Application: SSI 7485

I write regarding the proposed modification to M4-M5 Link, Mod 2 The Crescent overpass and changes to pedestrian infrastructure in North Annandale, Rozelle and Rozelle Bay Foreshore area.

Figure 4-2 Pedestrian and cyclist bridge infrastructure options

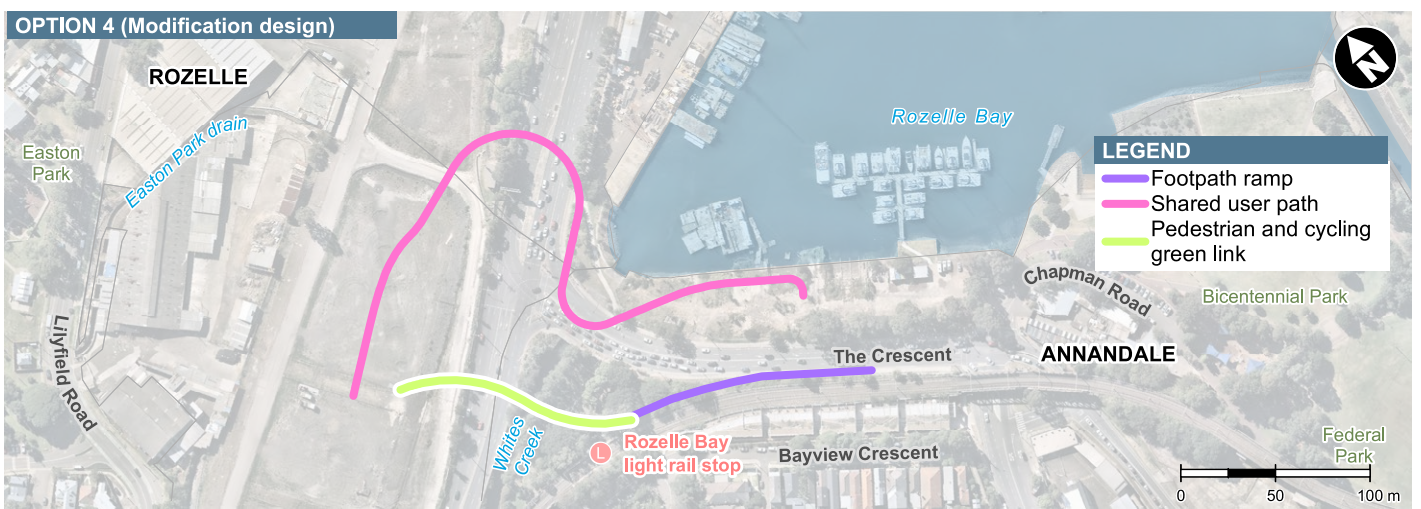
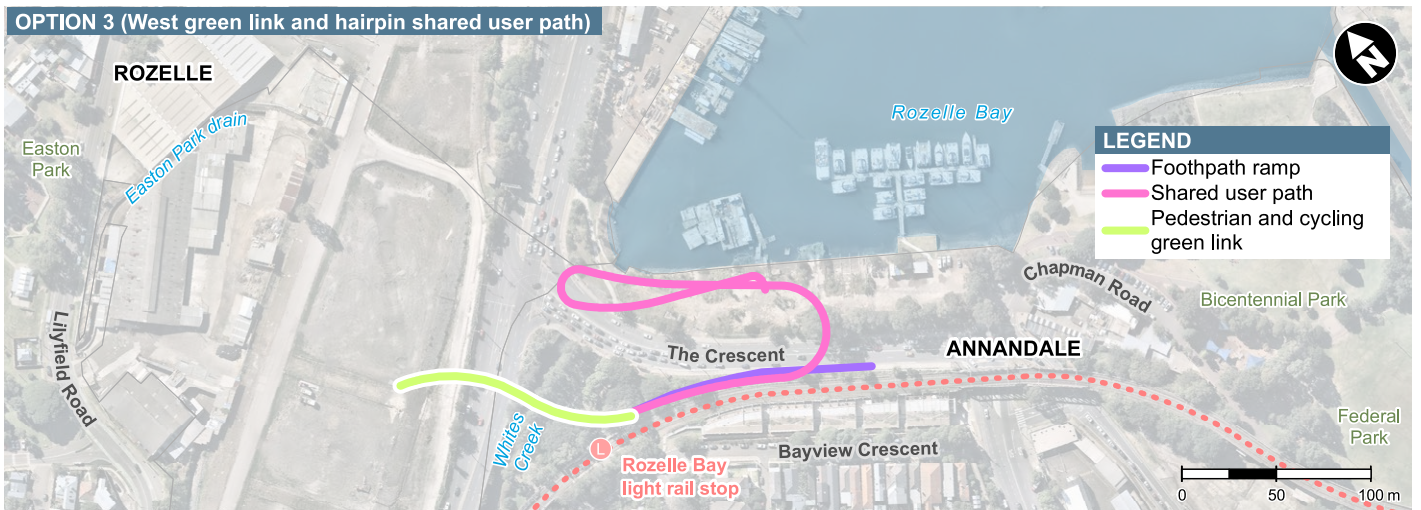
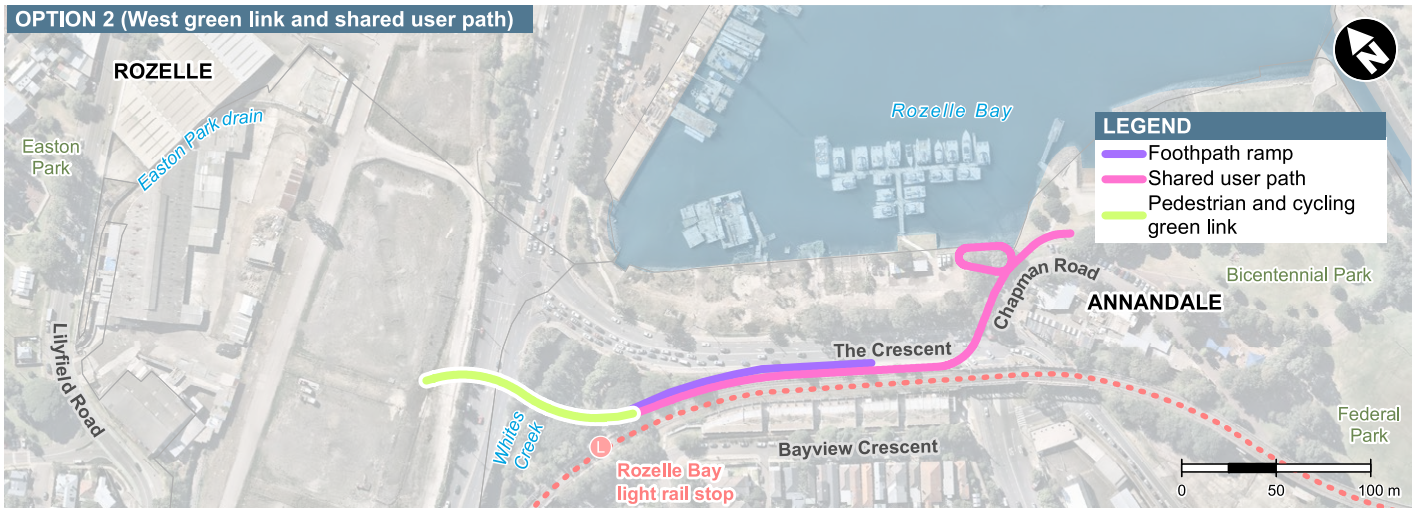
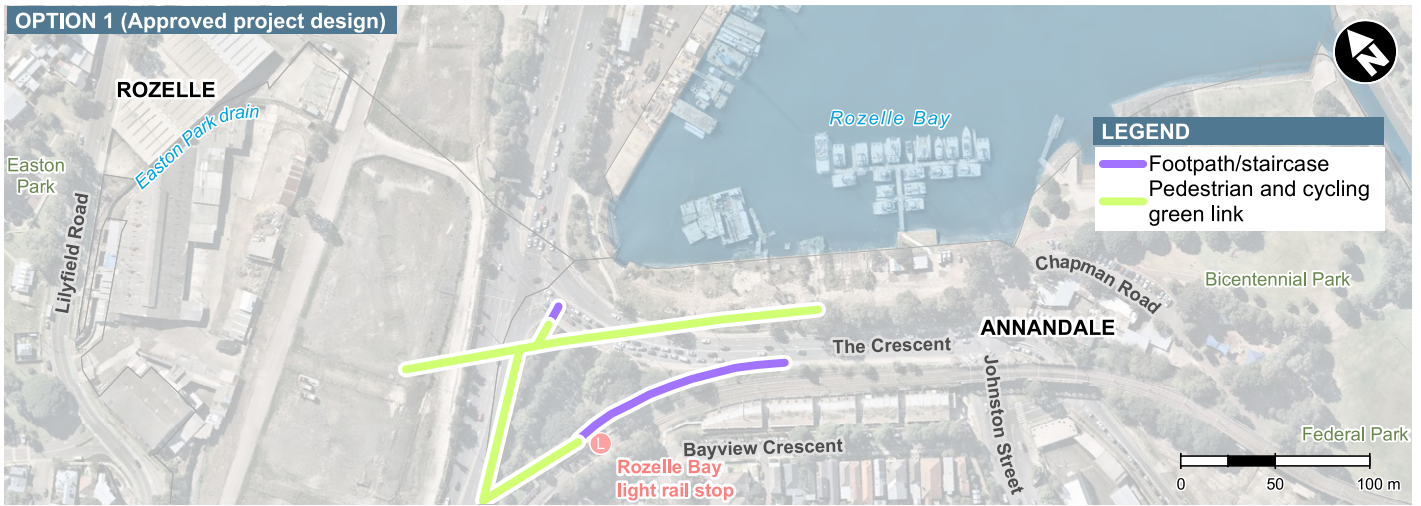
I request RMS work with the community to explore alternate design options to the proposed new car overpass design and the changed pedestrian and cyclist links. I am seeking the reinstatement of the safe, direct access from the approved EIS GreenLink to create a continuous green open space connection from the Rozelle Rail yards and Annandale to the foreshore. The GreenLink was more than just a walk way - it put people central to the design, maximising safety, and providing much needed accessible open space for the community now and into the future Bays Precinct design.

- The significantly reduced safety and increased risk for pedestrians and cyclists with removed access over The Crescent to Bicentennial Park and the increased traffic along Johnson Street.
- Being required to cross five sets of pedestrian lights at The Crescent as my option to reach the foreshore from Annandale or from Rozelle Bay light rail stop.
- Removal of direct active links to the foreshore, cutting the community off from the area and the proposed revitalisation of the entire Bays Precinct, including linking the Light Rail and Bus stops to a Ferry wharf and Metro station.
- Urban and landscape design that is being built before a finalised Masterplan for the area.
- Traffic changes that limit movements around the suburb and create further congestion in the local streets of Annandale, Forest Lodge, Glebe, Lilyfield and Rozelle with no planning to deal with these.

- Reinstate the GreenLink connecting communities and green open space from Rozelle to Bicentennial Park
- Relocate and design pedestrian and cyclist connections that are continuous, safe and direct.
- Design the modification infrastructure and active links in response to the character of the suburbs, the location of the foreshore and it's potential future development.
- Provide pedestrian and cyclist paths that maximise people safety and do not force them onto busier streets, unsafe concrete plazas and caged walkways.
- Integrate active and direct connections to all active transport – including the future Metro West and Foreshore Ferry Wharf

Figure 4-3 The Crescent, Johnston Street, Chapman Road intersection options

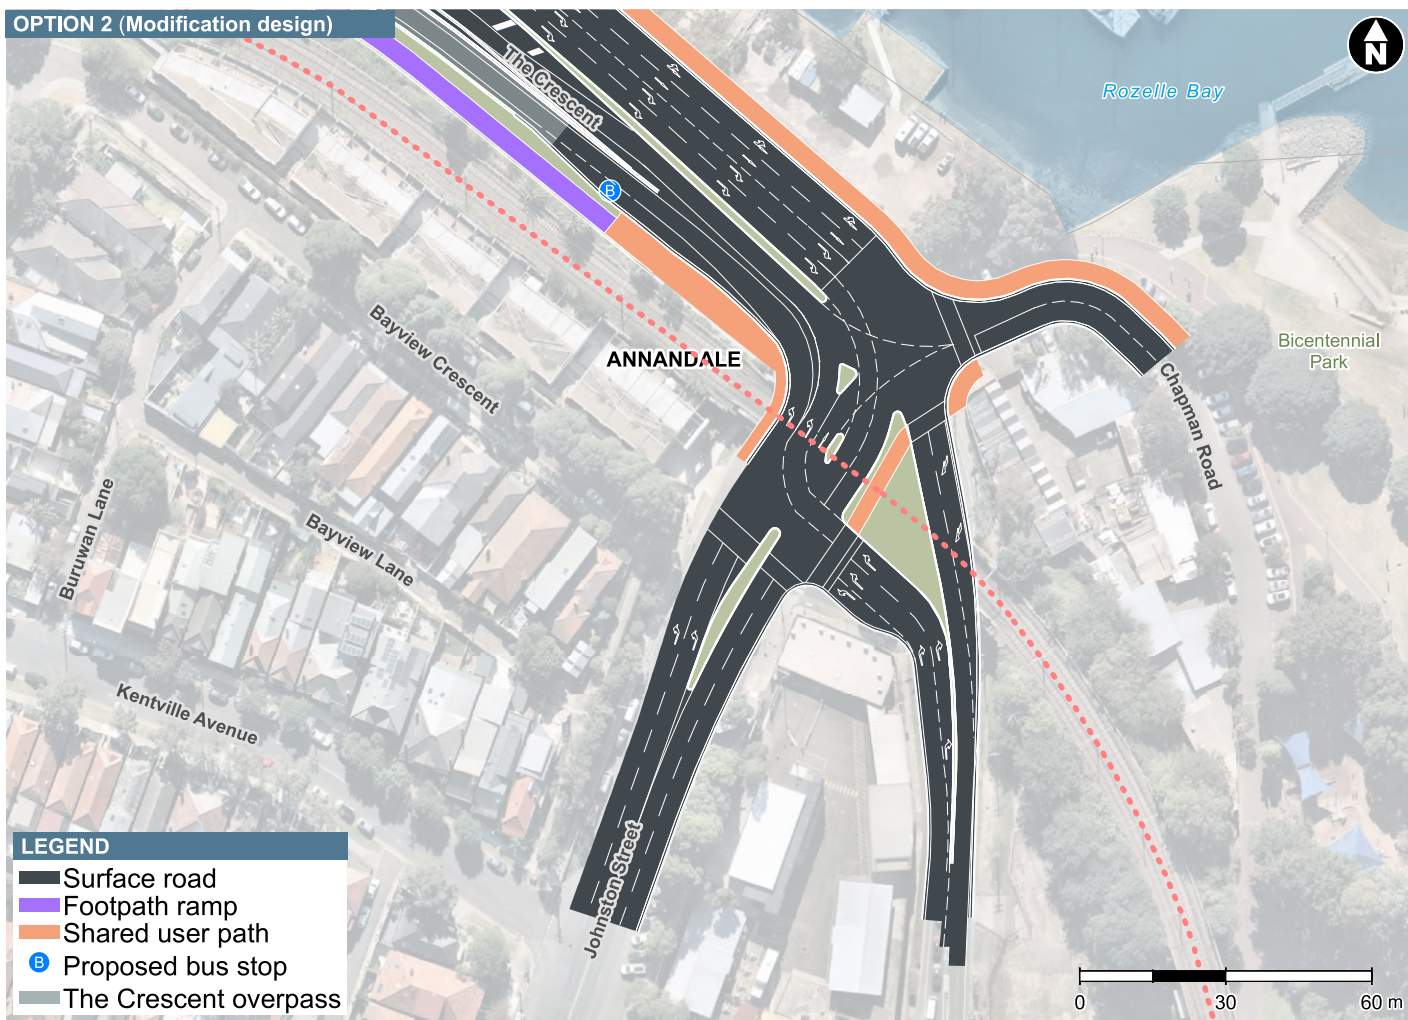
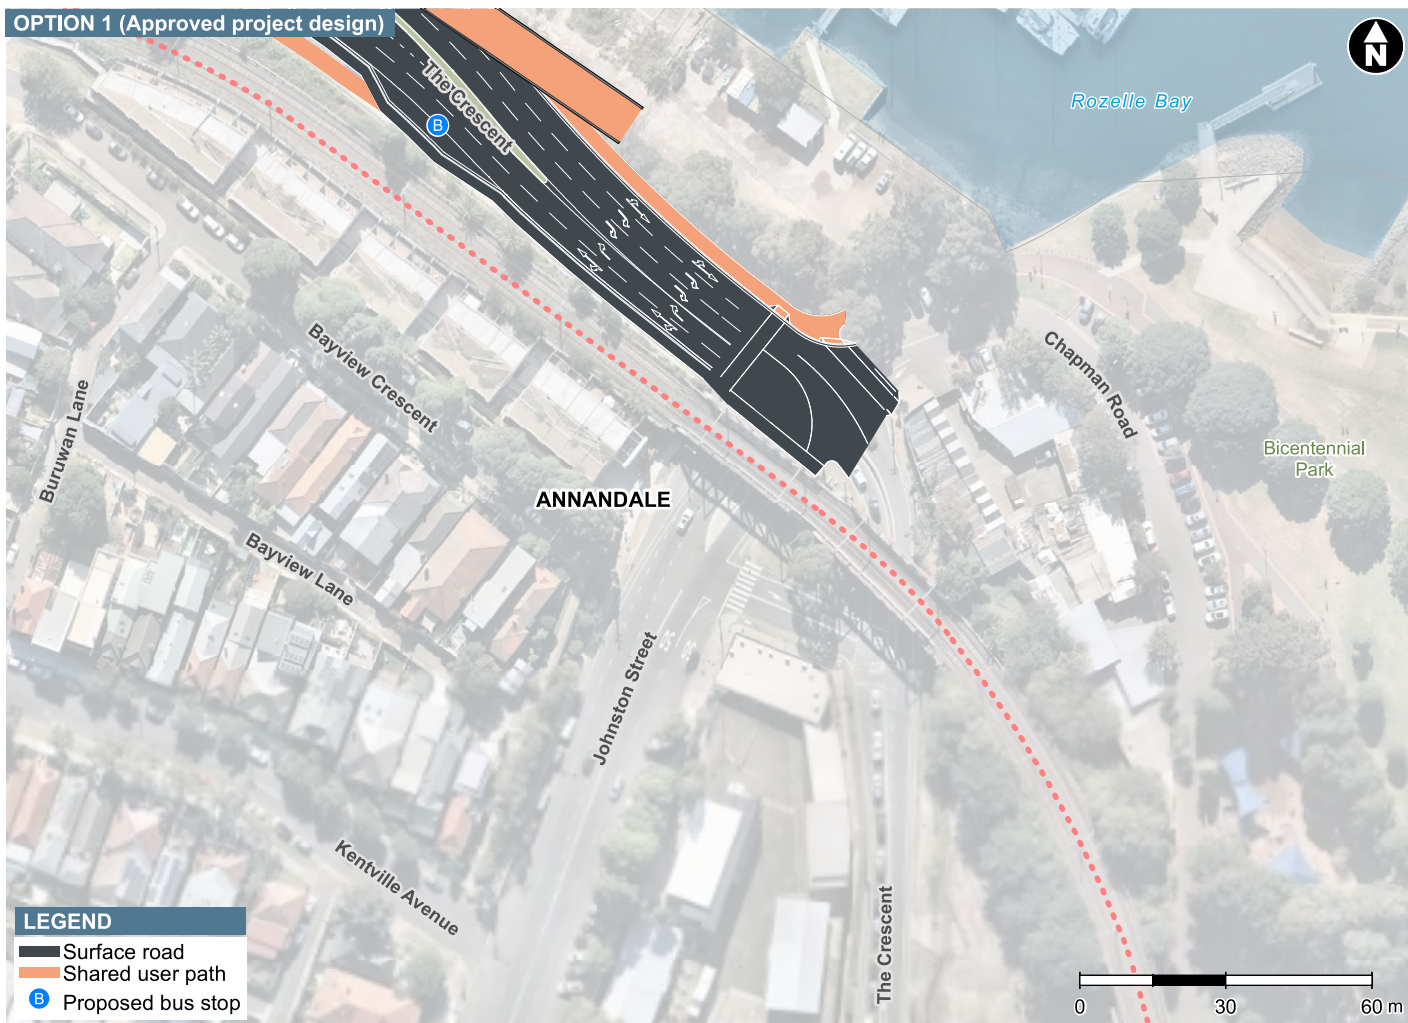
Johnson Street is a residential street with 3 schools. Our concern is increased traffic + reduced safety + accen for the community to the green space + foreshore.
